Recommendation Report for Planning Permission

REF NO:	LU/163/25/PL
LOCATION:	Strawberry Field Courtwick Lane Littlehampton BN17 7PD
PROPOSAL:	Amendment to LU/59/24/PL to allow for the formation of overspill car park, rationalisation of existing car park and formation of residents garden including fence panels (resubmission following LU/310/24/PL). This application may affect the setting of listed buildings and is in CIL Zone 2 (Zero Rated) as other development.

DRAWING TITLE:
101 - P1 - PROPOSED SITE PLAN
PROJECT NO: **24890** DATE: **DEC 24** SCALE: **1:500 @ A3**

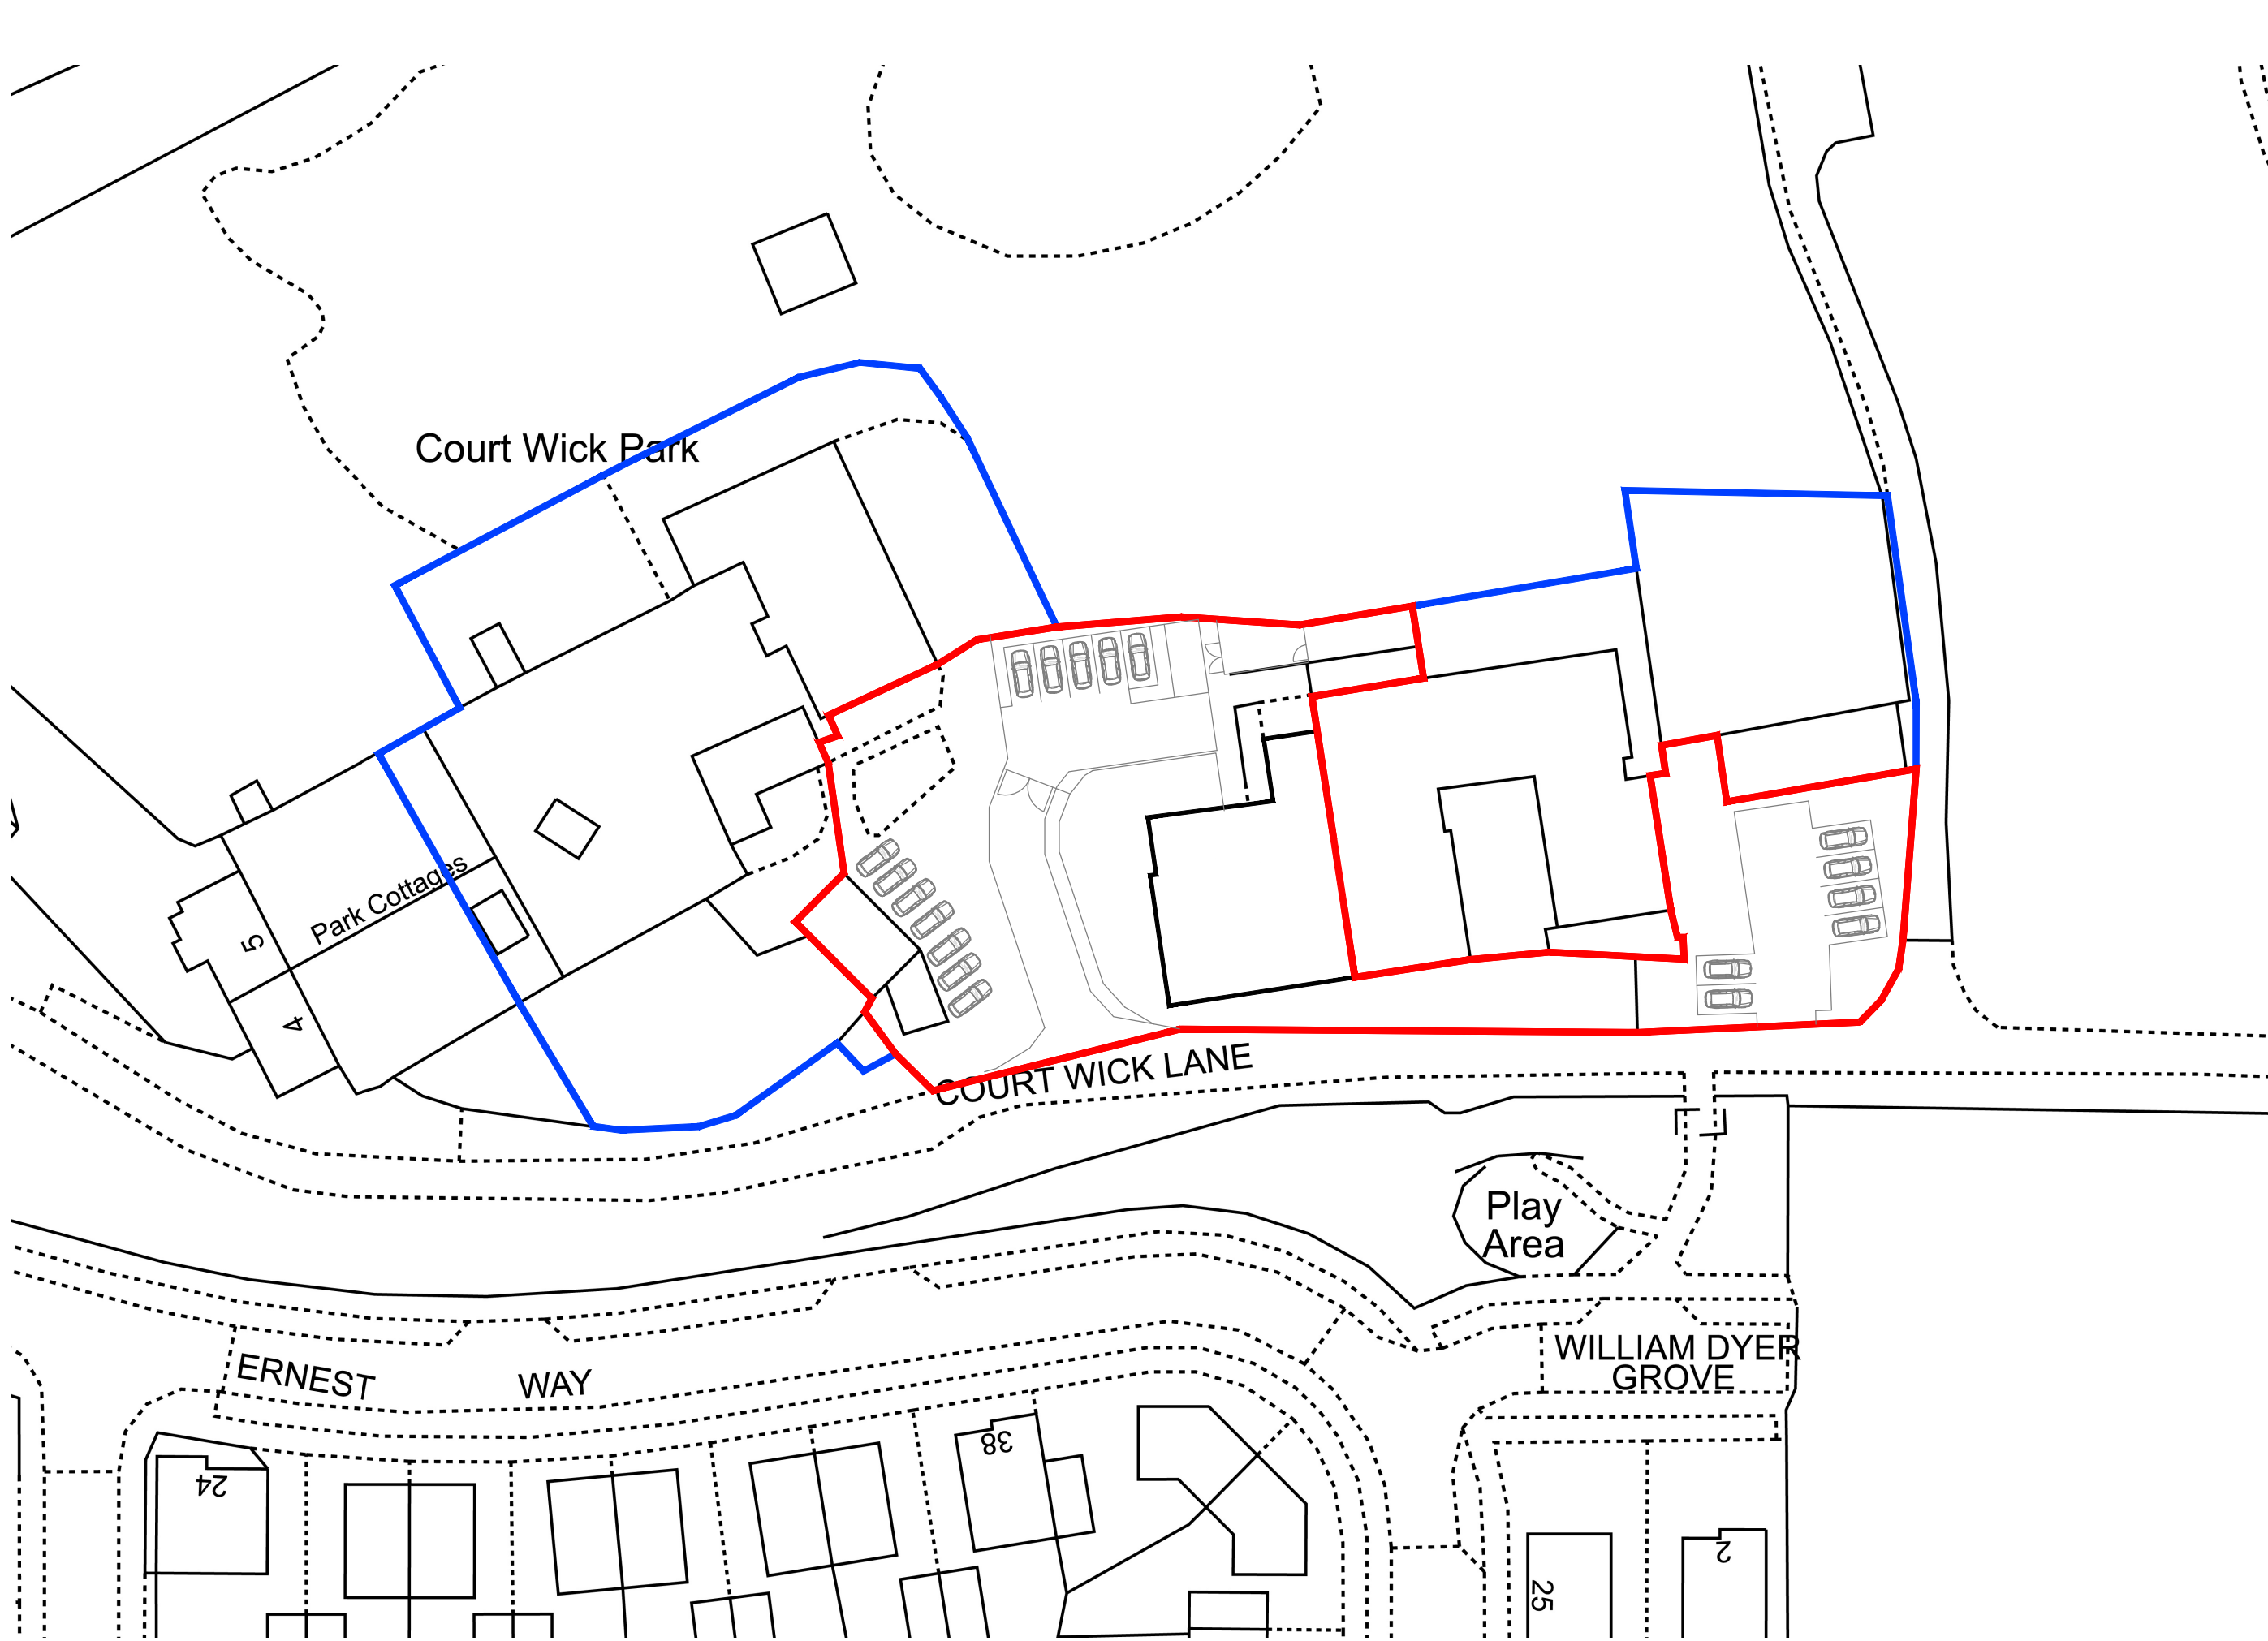
The overspill staff parking will be created to the east of the site, on an existing open space laid to lawn. This space serves as a green space which contributes positively to the semi-rural character and nature of Courtwick Lane. The development will result in the partial surfacing of this lawn with asphalt, to create 6 new parking spaces. Soft landscaping and planting will subsequently be utilised in the remaining lawn areas, to screen the parking and soften this space. The creation of this parking area will result in the introduction of a suburban character within the street scene, which will appear incongruous with the existing openness this space currently affords the lane. Whilst this will change the character and appearance of this part of the site, and the surrounding street scene, this harm to visual amenity is not such that it warrants refusal. The soft landscaping and planting proposed will aid the screening of this parking area, and help to retain the semi-rural and green character of Courtwick Lane, and subsequently will negate any demonstrable impacts on the character and appearance of this street scene.

The rationalisation of the parking area will comprise the installation of 10m of 1.2m high estate style fencing and gate. This will separate the parking for Strawberry Fields from the access to parking for Court Wick Park House, and will create an additional access point within the driveway to these two properties. This will be set 20m from the street scene, and as a result of its modest and low height, will not unduly intrude on the visual appearance of the site nor its surroundings. This is a substantial improvement from the previous boundary treatment proposed under LU/310/24/PL, and subsequently

The proposal will include the creation of a lawned garden for residential use, with approximately 40m of 1.8m high timber close boarded fencing to the south, west and north elevations. It is understood a fence of this height is deemed necessary for the privacy and security of the associated residents. Whilst this fencing on its own would result in a closed and utilitarian appearance to the entrance of the site, which would have negative implications to the open and green character of the street scene, a hedgerow has been proposed to the front of this fencing. This hedging will help to screen the fencing from the public realm, and will soften this boundary to the front entrance and principal elevation of the site. Whilst this will result in some enclosing of the street scene, by bringing high level boundary treatment close to the highway, the installation of soft landscaping will help to create a relief between built form, and will reduce the imposition of this fencing on the character and appearance of the street scene.

DRAWING NUMBER / TITLE
902 PLANNING - SITE PLAN (PHASE 2)
PROJECT
STRAWBERRY GROVE, LITTLEHAMPTON

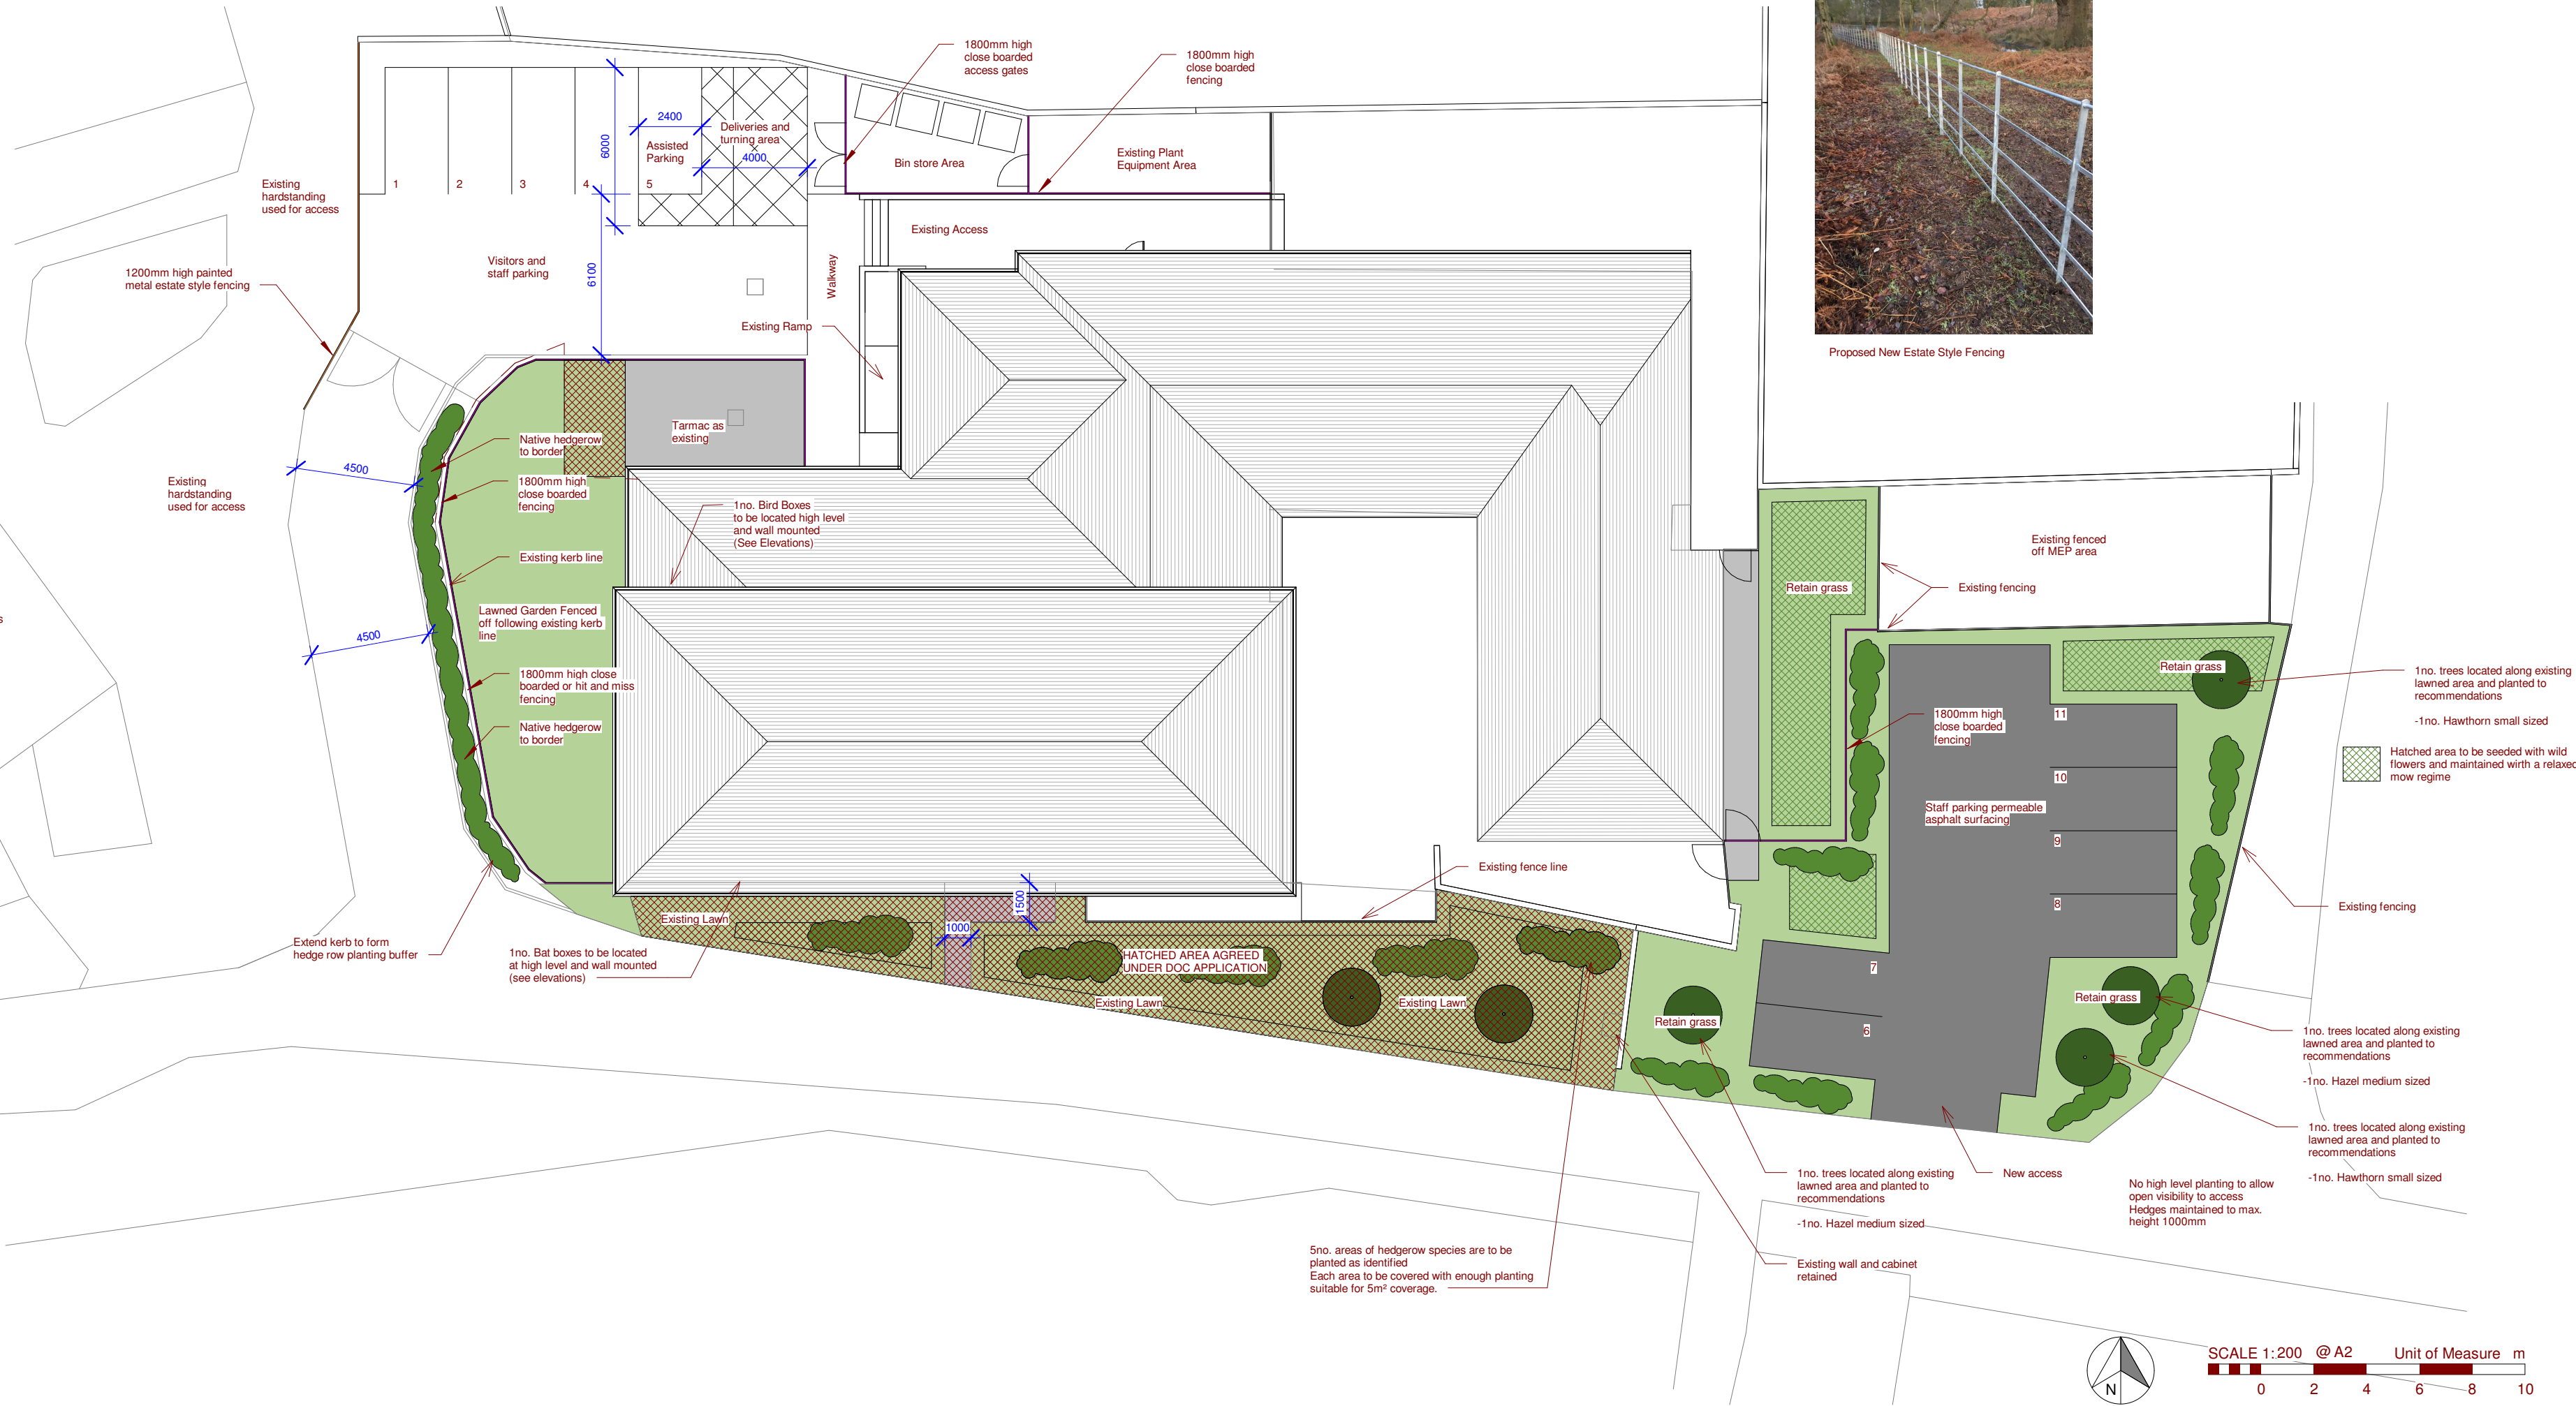
The new parking and access will comprise an alteration of the existing vehicular access, creation of a smaller car park to serve the host building, enclosure of the existing garden areas using 1.8m high fencing with hedging to the front, and introduction of two enclosed storage areas. The use of estate-style fencing to create the revised access point is a positive and sympathetic feature, however should be finished in a colour that complements the sensitive context. The 1.8m high fencing is less sympathetic, and does have more impact on the setting of the heritage asset. However with a permanent hedgerow feature to the front, this fencing will be screened, and softened from the view. This will aid the preservation of the setting, and enjoyment of the heritage asset from the public realm. In order to further soften the fencing, the wood should be left to weather naturally to a silver tone. This is subsequently conditioned below, to ensure that appropriate detailing and landscaping is secured.

At present, the area to the east is laid to lawn, and complements the semi-rural setting and character of Courtwick Lane. This lawn provides an attractive approach to the site, and to the settings of the listed buildings. The creation of the car park, and subsequent introduction of parked vehicles would result in visual intrusion, by introducing a suburban feature that does not positively benefit the historic and characterful setting. The material finish of asphalt surfacing further exacerbates this.

Planting is proposed to soften the visual impact and intrusion of this suburban feature. However, there is currently little detail as to what this planting would currently entail, nor what its overall appearance would look like. Subsequently it is necessary to impose a condition requiring further landscaping and planting details to ensure this landscaping is appropriate.

- a) Details of all materials and finishes (including colour / treatment) to be used for the proposed fencing / boundary treatment;
- b) Details of all landscaping and planting to be used within the staff car park (to the east of the site)
